Submissions Report

MIXED-USE DEVELOPMENT WITH IN-FILL AFFORDABLE HOUSING AT 241-245 PENNANT HILLS ROAD, CARLINGFORD

(SSD-84699461)

Commercial Waste Transfer Pathways

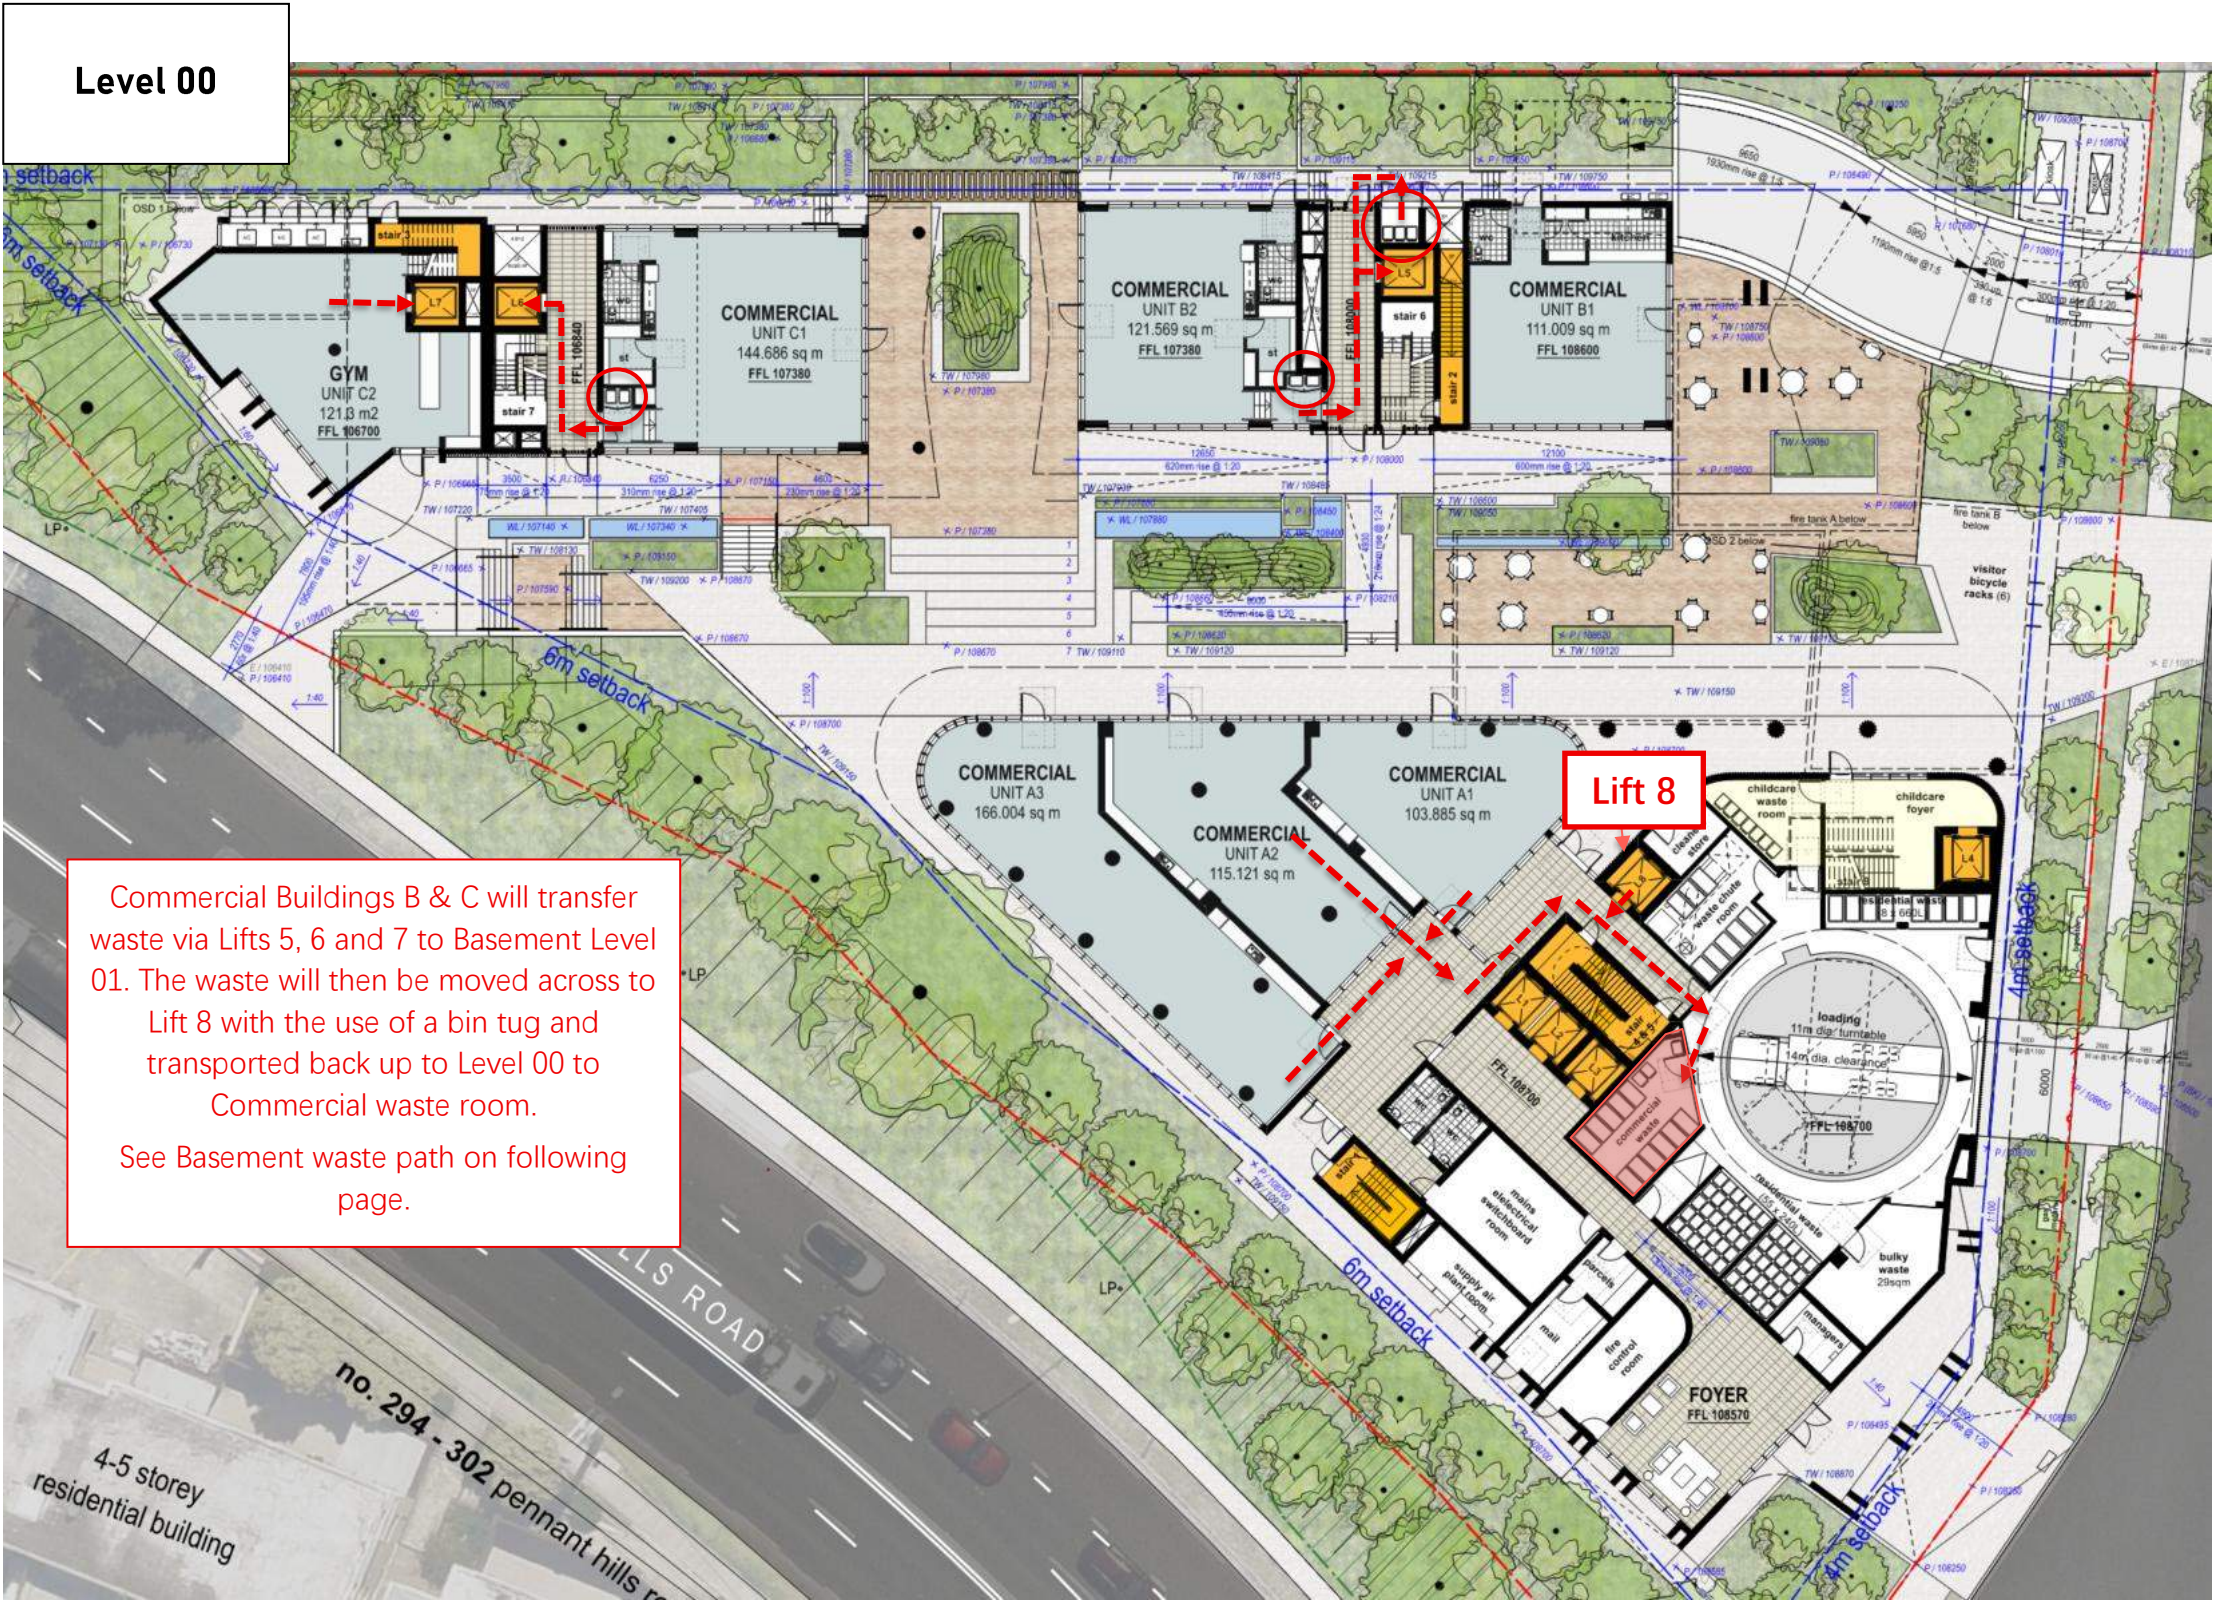
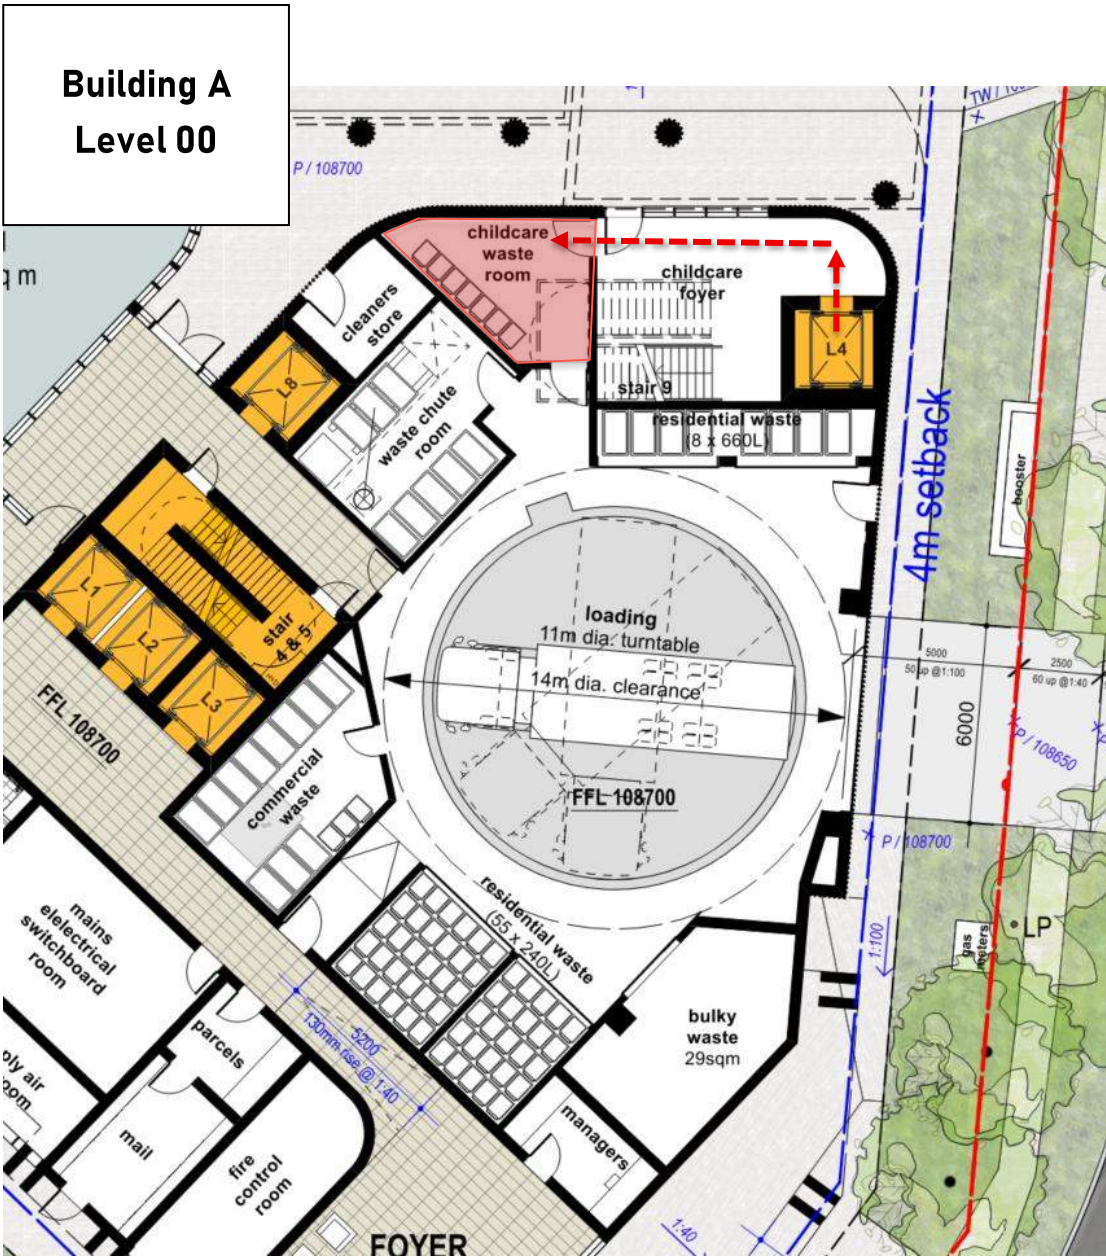
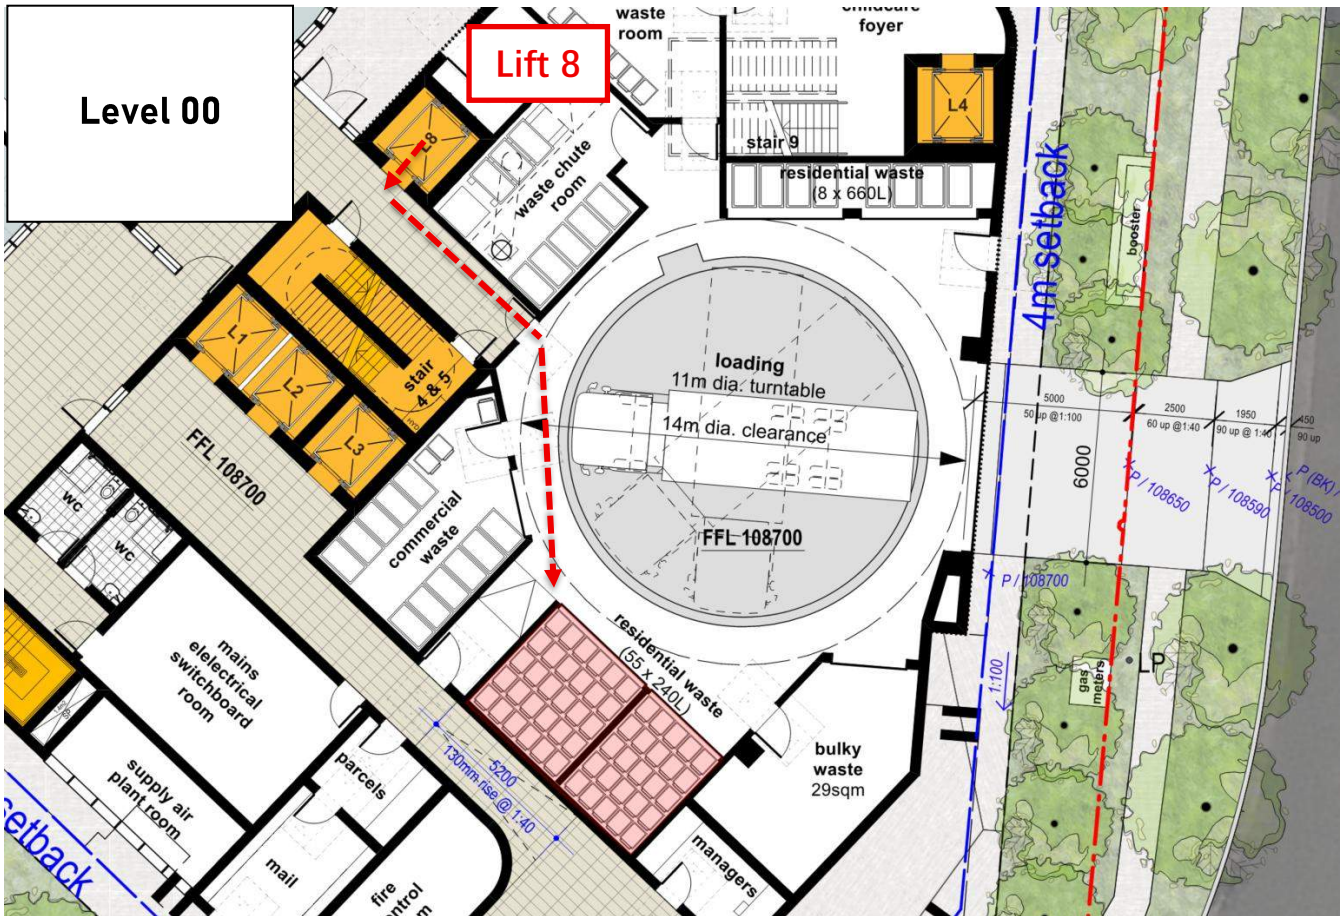
b) The proposed waste management arrangements indicate that building manager/caretaker is responsible for moving the waste bins from Buildings B and C on the western side of the site to the collection area in Building A. Appendix B of the WMP indicates the path of travel for commercial via the pedestrian site link/ central forecourt, however the WMP does not indicate: ○ residential movements from Buildings B and C on the western side of the site to the collection area in Building A. ○ what time of day these movements from Buildings B and C on the western side of the site to the collection area in Building A will occur, nor the frequency. The number of movements of bins through the central forecourt should be limited, as well as the time of day, to ensure that it occurs at a suitable time where there will be minimal pedestrian conflict whilst adhering the noise management measures. c) Clarify the location of the vehicle loading areas for all land uses. It is unclear if the loading area within the waste collection area is being used for delivery of goods to commercial premises, and if so, details need to be provided regarding how this area functions and any conflict between deliveries and waste. d) Provide details of how removalists will service the proposal.	The connectivity between the commercial tenancies and the loading area and waste holding pens has been revised and improved. The loading dock and turn table will be used for waste collection and furniture trucks. Arrangements for use of the loading facility will need to be made with management of the building to avoid conflicts between users.
